NON-MATERIAL AMENDMENT APPLICATION – LAND TO THE NORTH AND EAST OF WARREN MILL HOUSE, ELMSWELL ROAD, WETHERDEN

PERMISSION TO BE VARIED: DC/23/01809

This Non-Material Amendment application to alter the design of the garages approved under variation of conditions application DC/23/01809.

GARAGING - PLANS & ELEVATIONS AS PROPOSED.

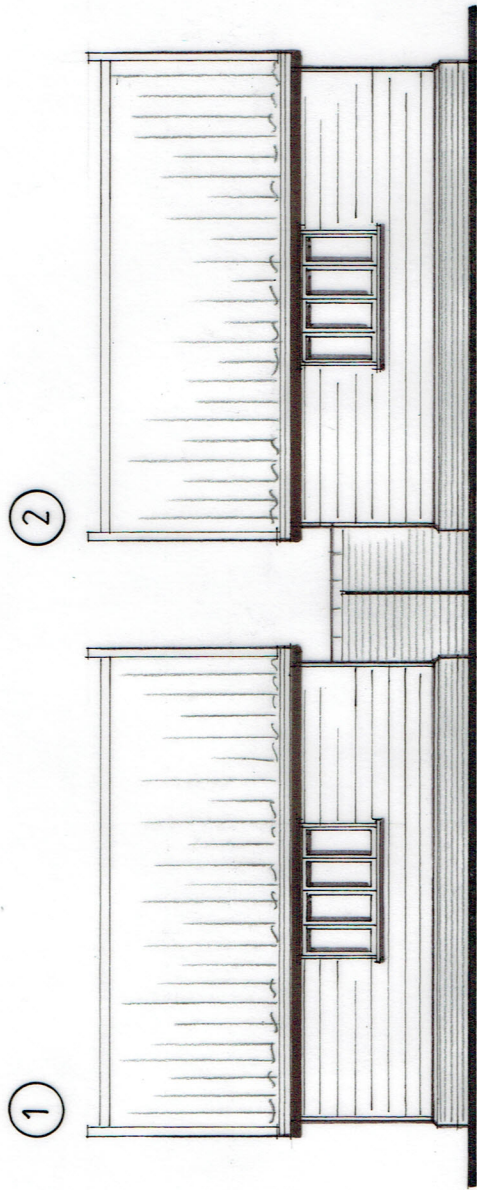
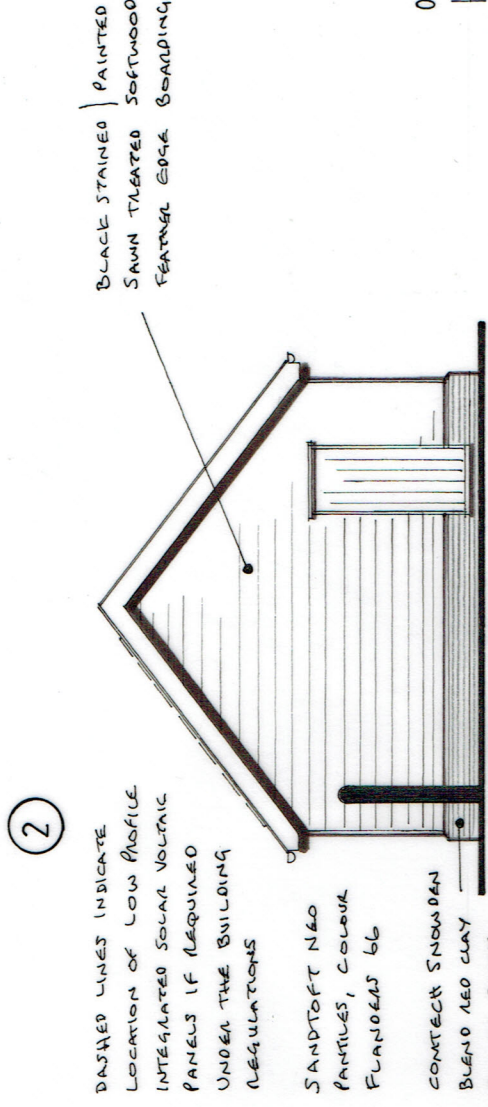
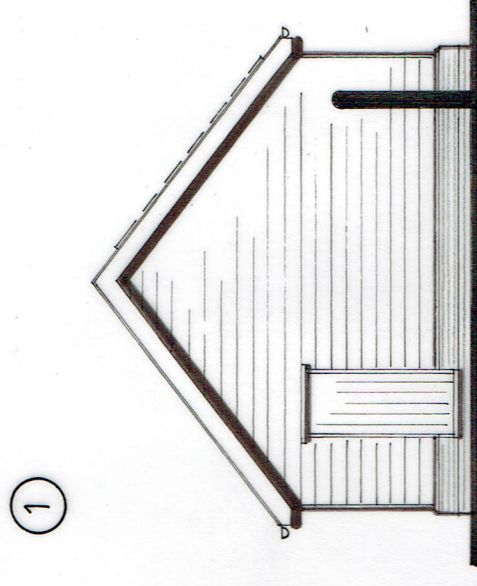
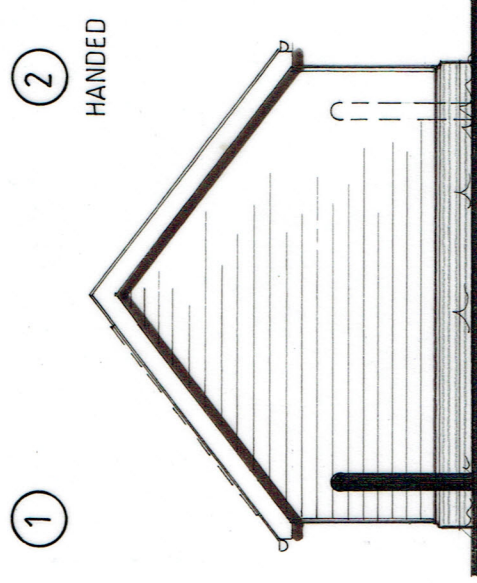
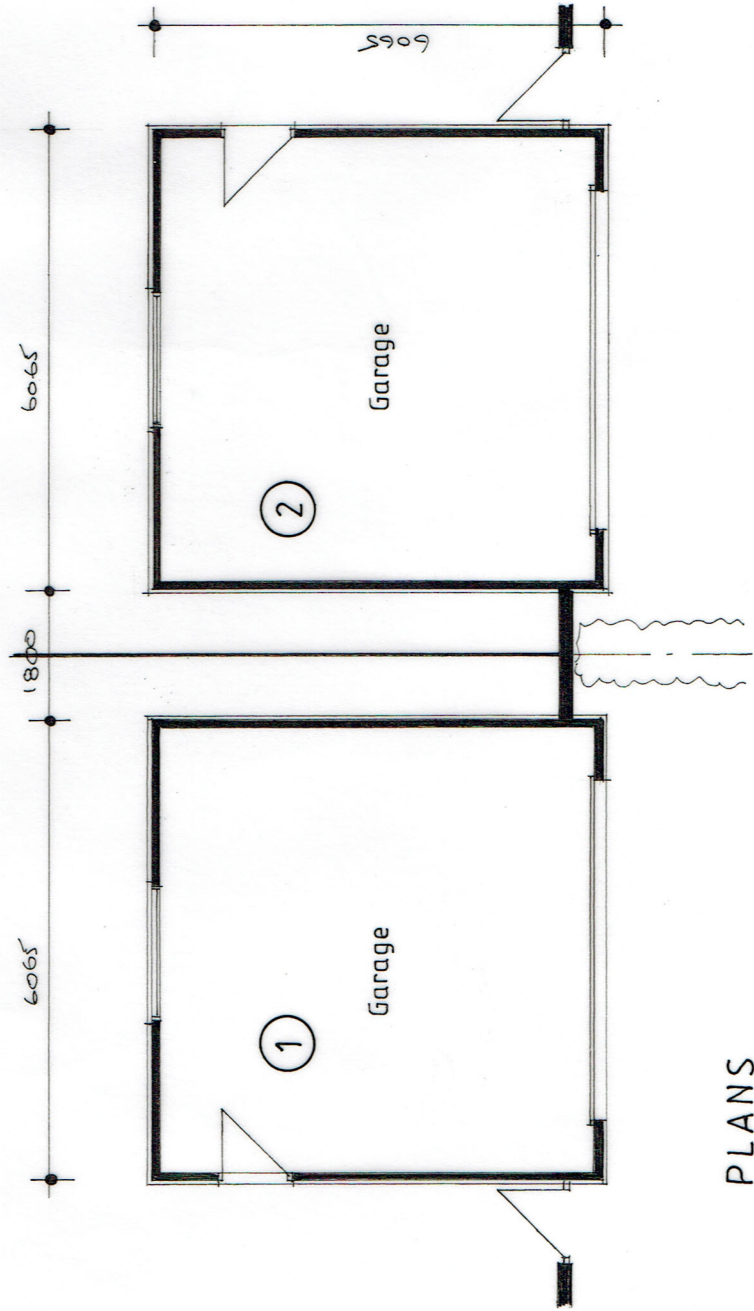
As approved, the garages between Plots 1 + 2 are semi-detached and share a party wall. This non-material amendment proposes that the garages are split. This will break up the form of the development when viewed from the road and will provide more desirable garages to the occupants of the houses which will not share a party wall which will simplify the maintenance of the garages and remove any likely disputes.

~~Plans - Proposed 2238-04 Garaging Plots 1 and 2 - Received 15/04/2023~~ Plans – Proposed 2238-05 Garaging – Plots 1 and 2
